Application No: R/89/21/HH
Site Address: 74 The Martlets Rustington BN16 2UE
Description of works: Erection of a timber single storey granny annexe for ancillary use to the main dwelling.

Thank you for your internet representation made on 21st May 2021 which has been recorded as an objection with the comments as follows:

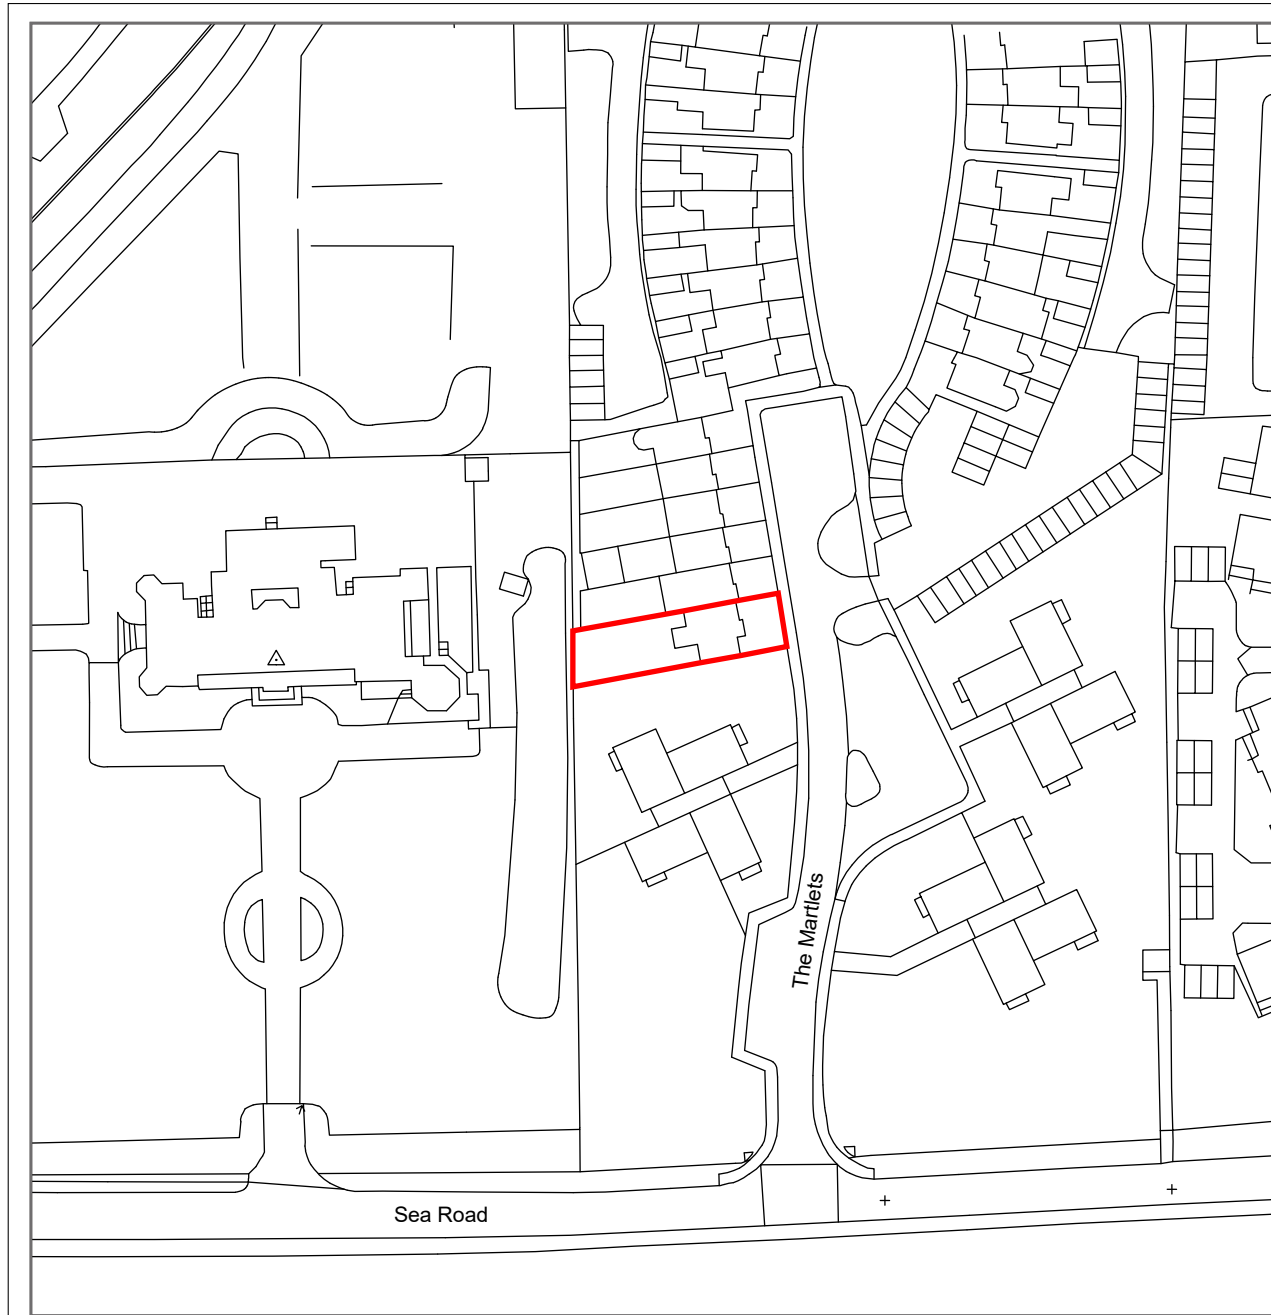
Due to the planned roofing style of this building, it would end up being greater than 2.5m high and would cause a drastic light reduction to the neighbouring gardens and be a blot on the landscape as well as disrupting the neighbours view of the sea.
